North Falls Offshore Wind Farm Ltd – EN010119

Section 51 advice regarding draft application documents submitted by North Falls Offshore Wind Farm Ltd

On 24 May 2024 North Falls Offshore Wind Farm Ltd submitted the following draft documents for review by the Planning Inspectorate as part of its Pre-application Service¹:

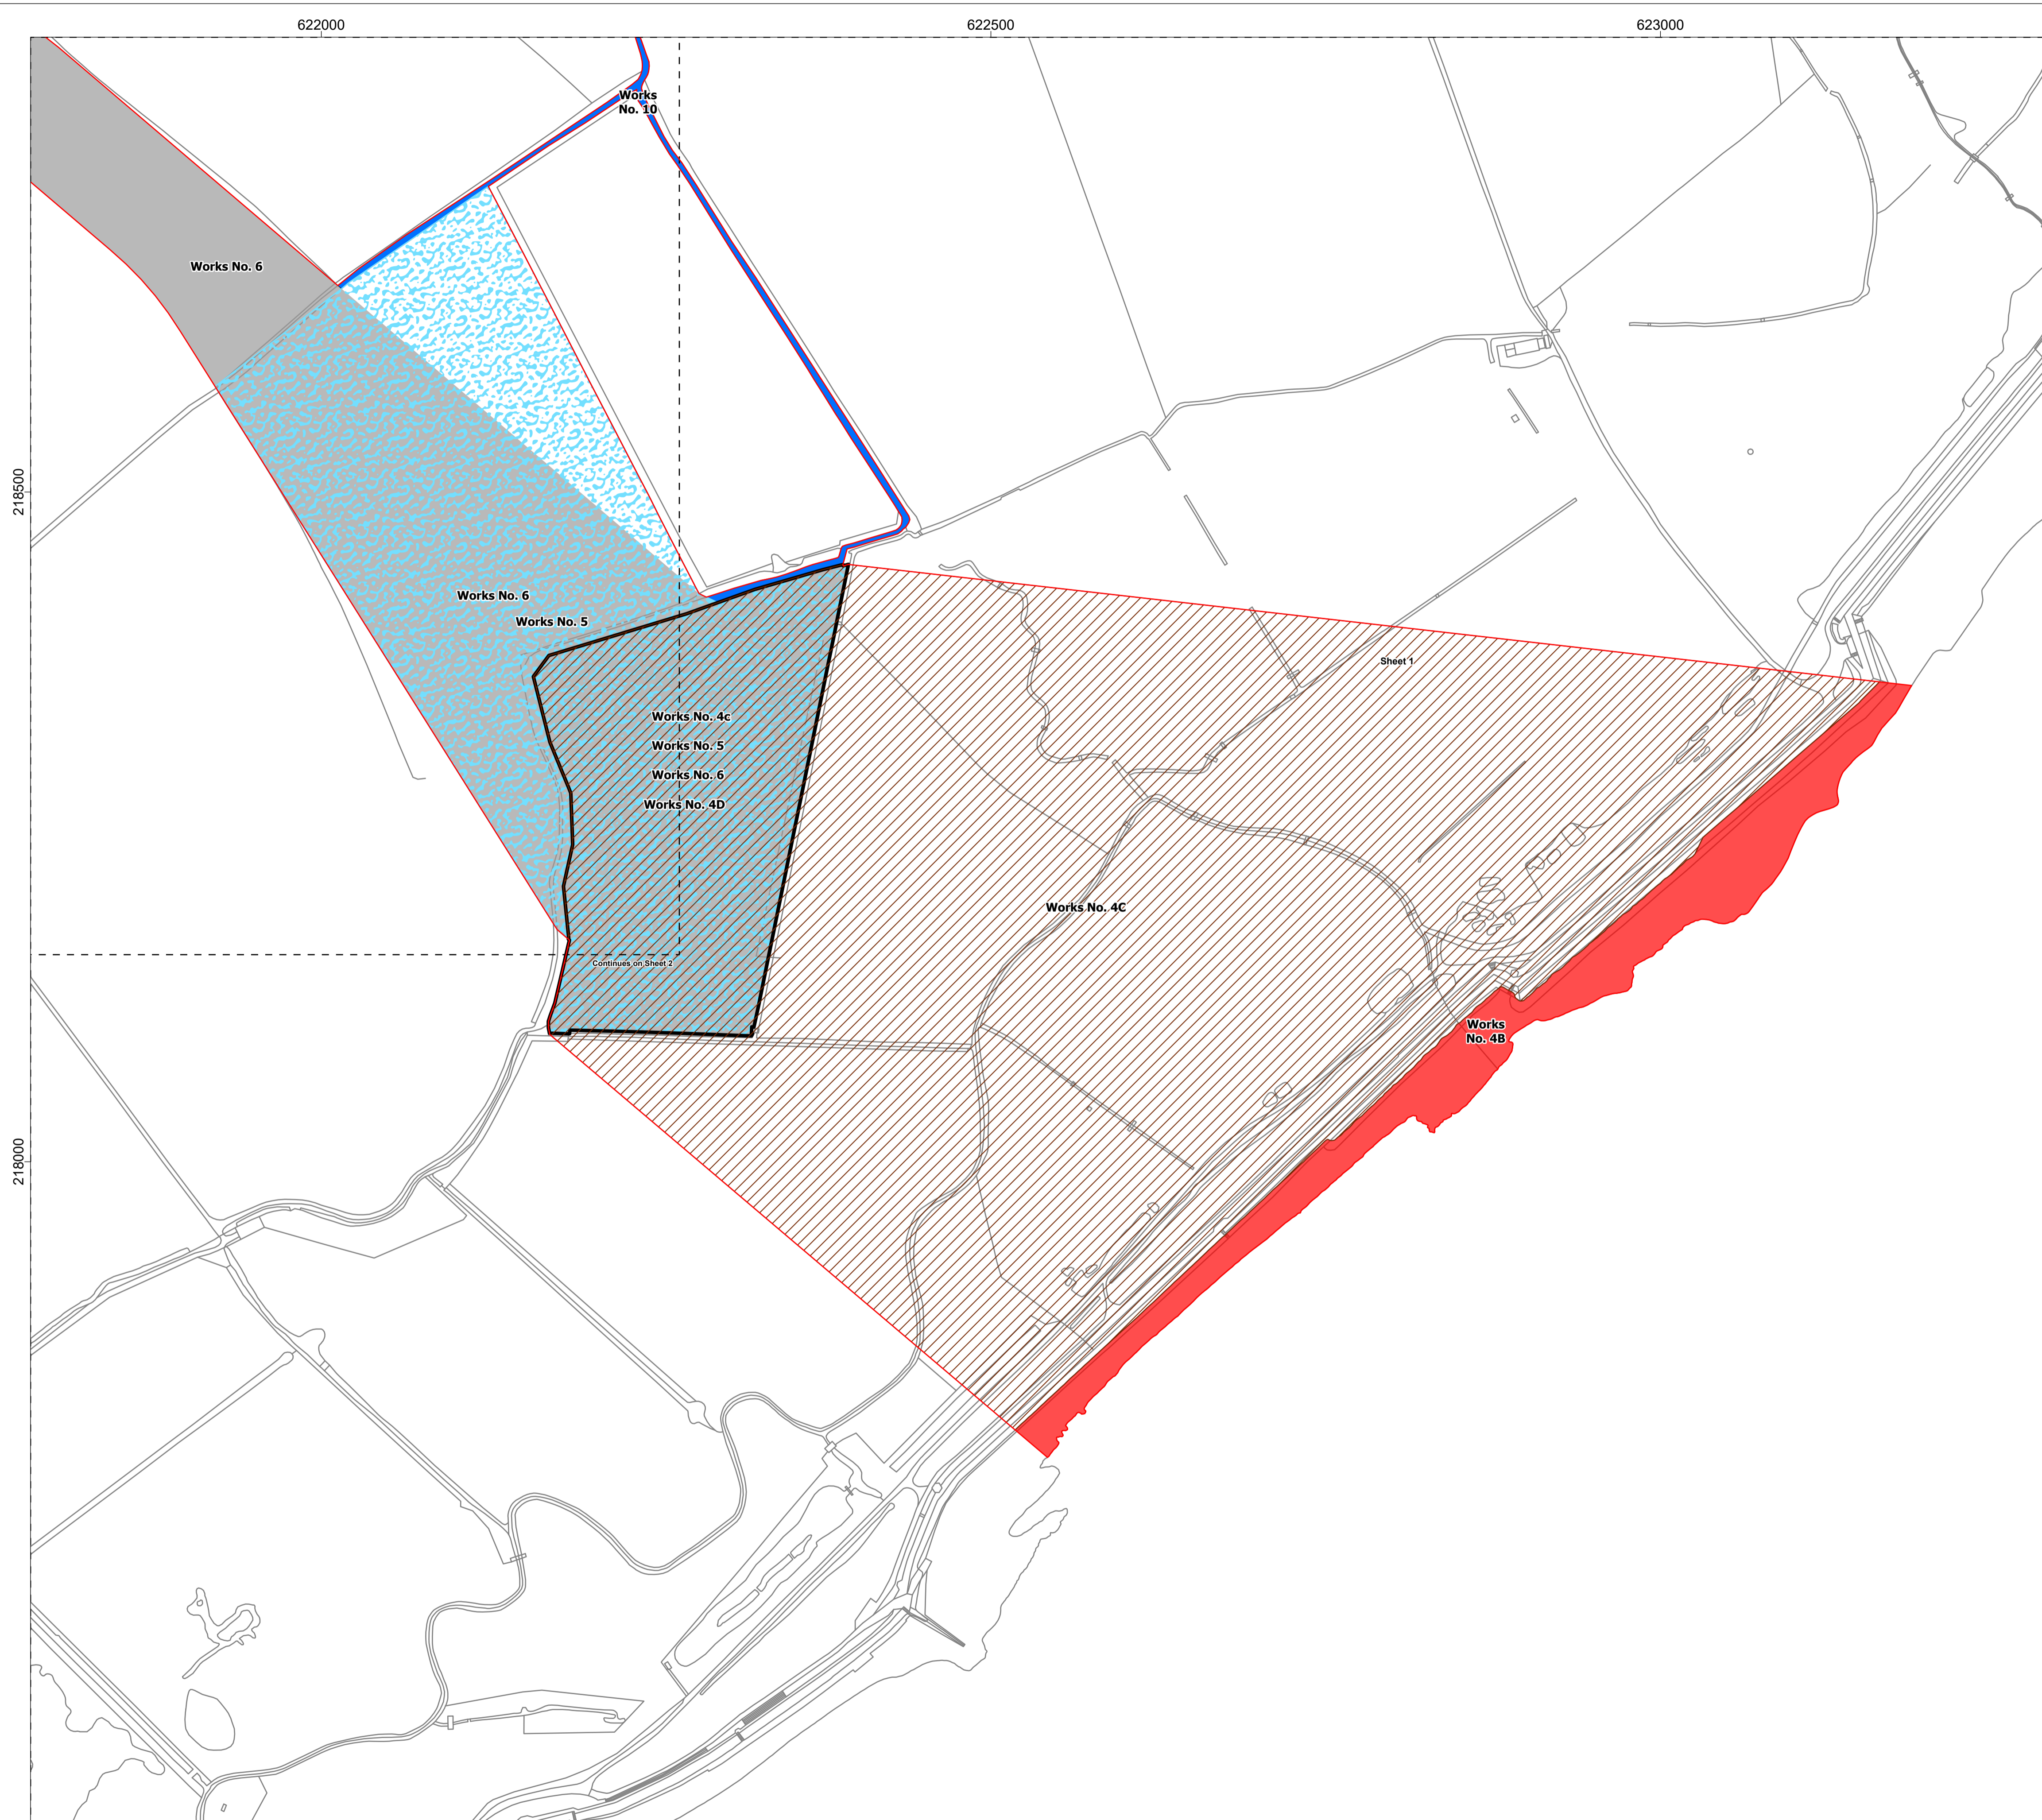
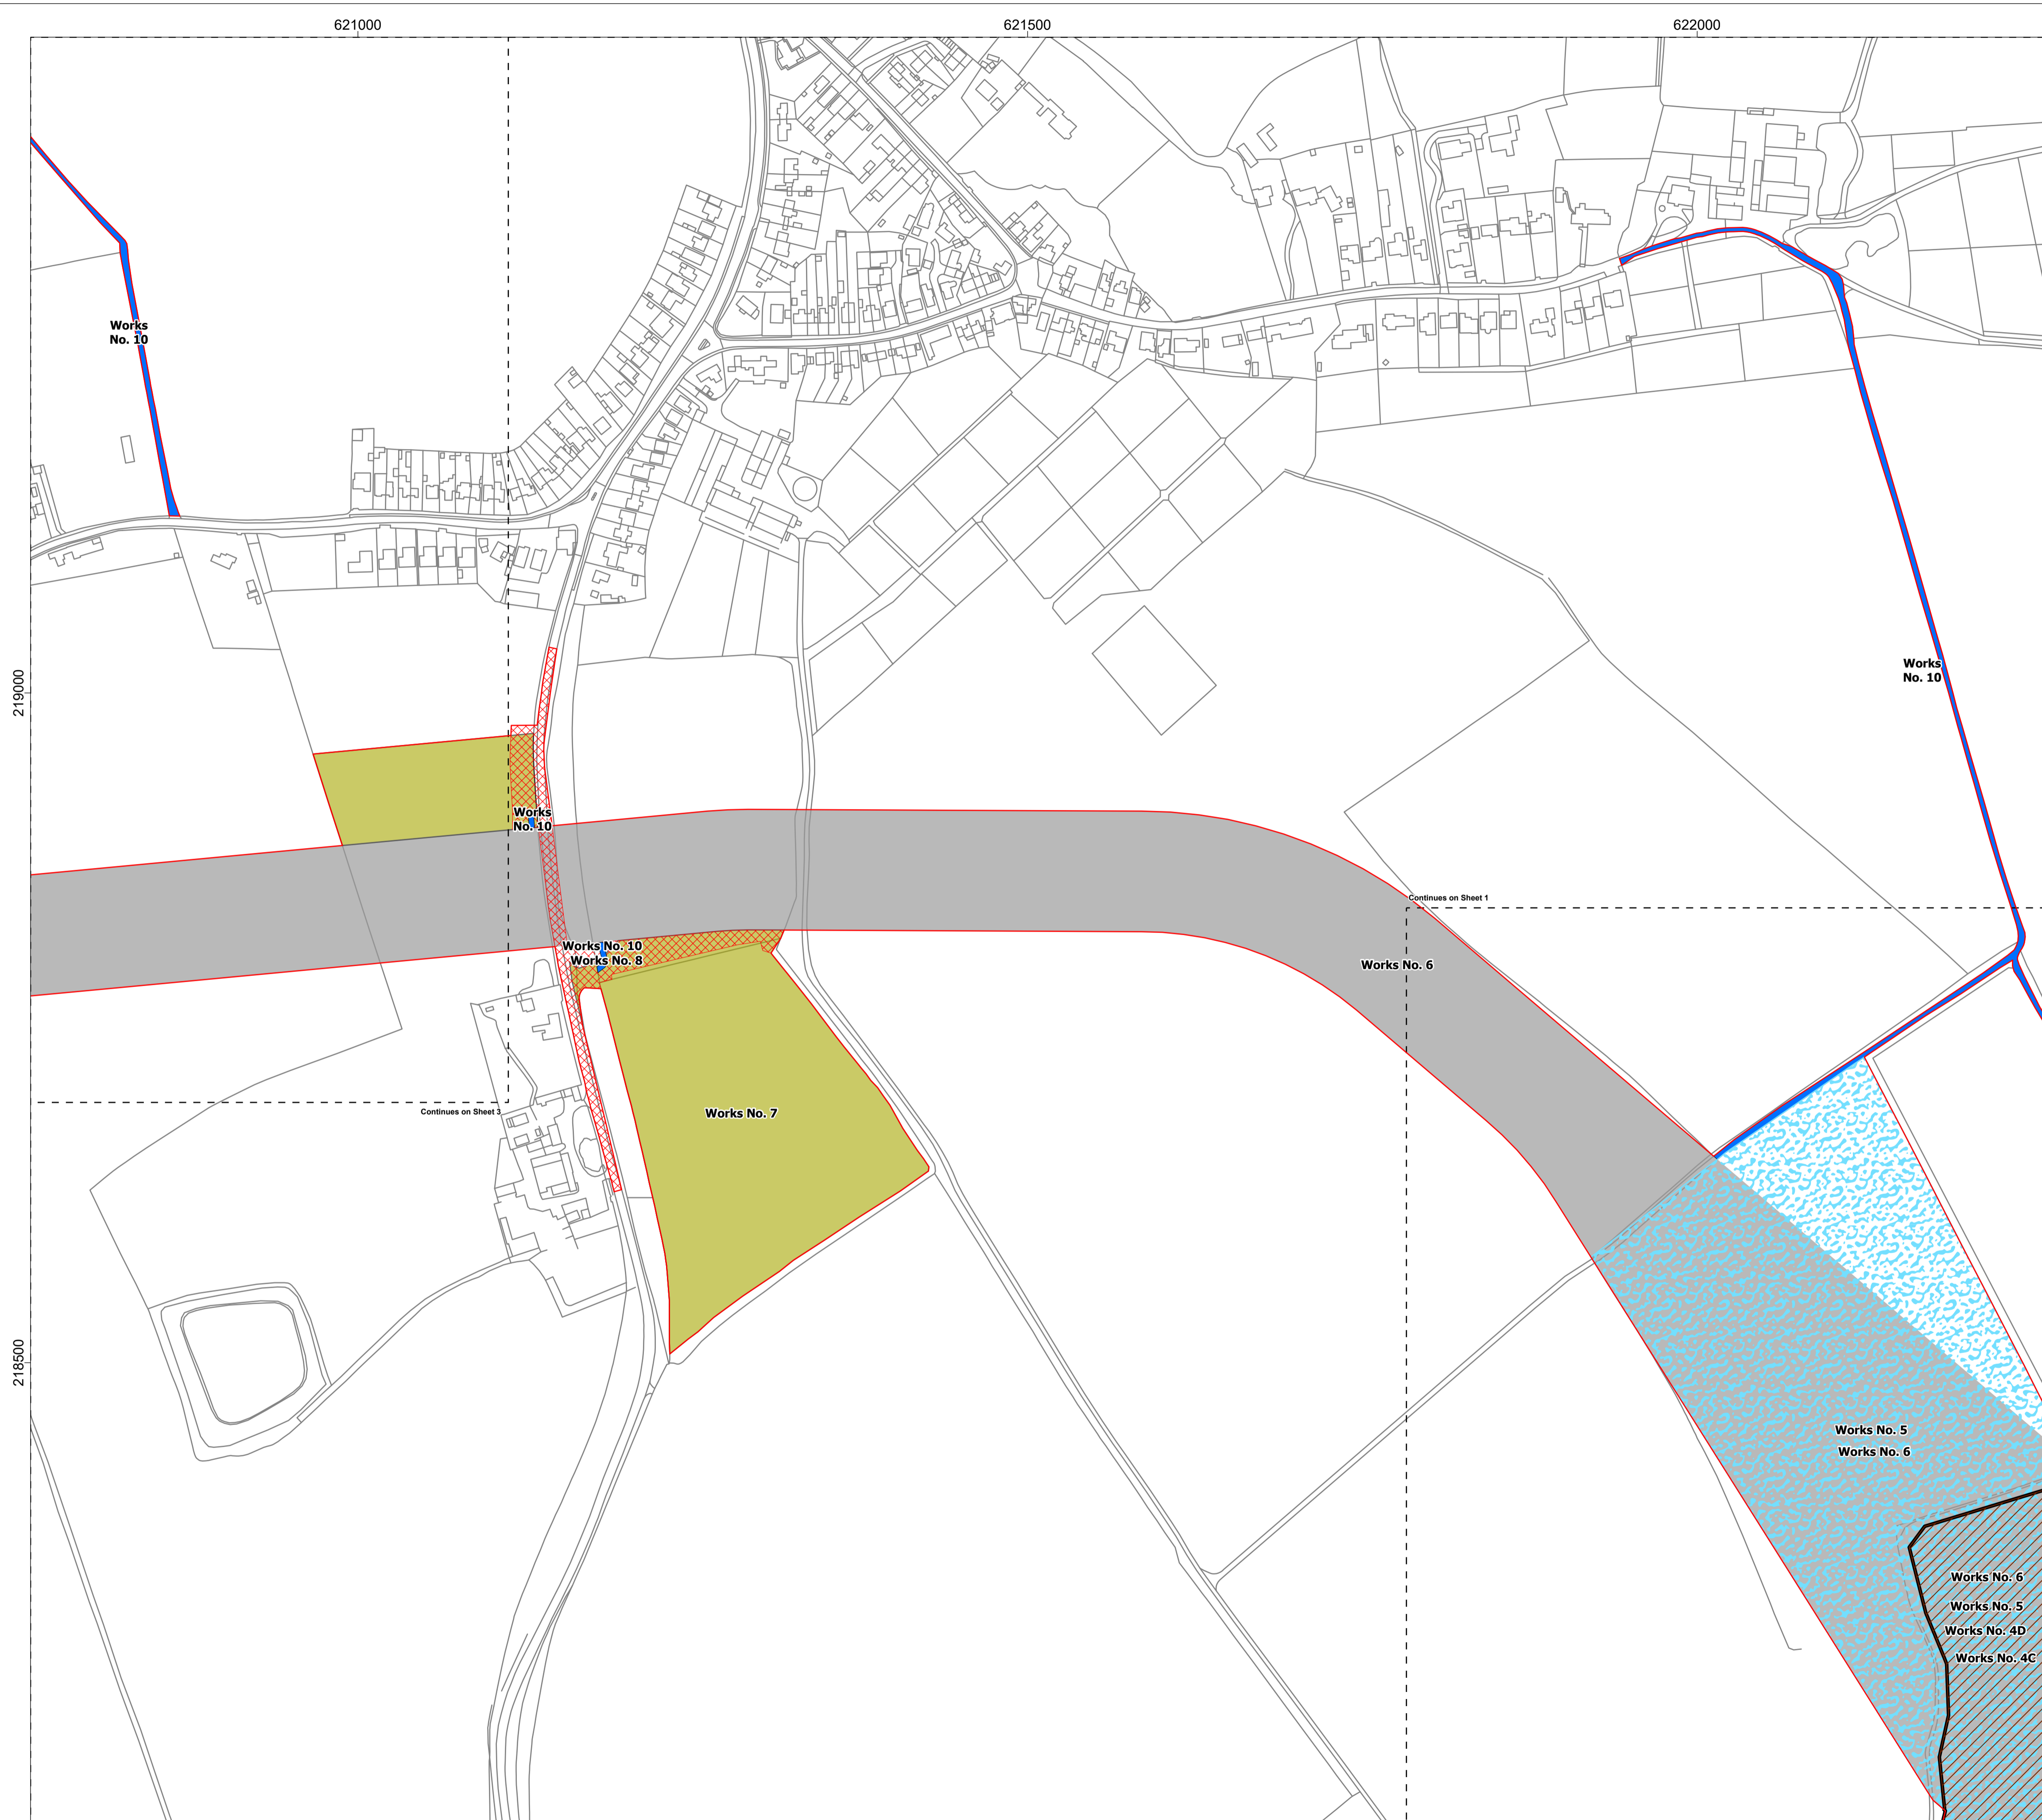
8.	Each sheet contains all Work numbers even when that work does not appear on the sheet. The Applicant could consider whether this is confusing to the user. Eg 4d is on Legend for all sheets but is not present on all of them

9.	The Legend states, 'Works numbers' and the dDCO refers to Works numbers, but the references in the plots start with 'WP' and not 'WN'. The Applicant may wish to consider renaming the Works numbers to make it clear that the ref is to the Work number within the dDCO and not a Work Plan.

Onshore plans		
Ref.	Plan ref	Comment or question
12.		The Works Plans do not contain any identifying information, such as village or road names, which the public may wish to use to identify their properties, land or other areas of interest.
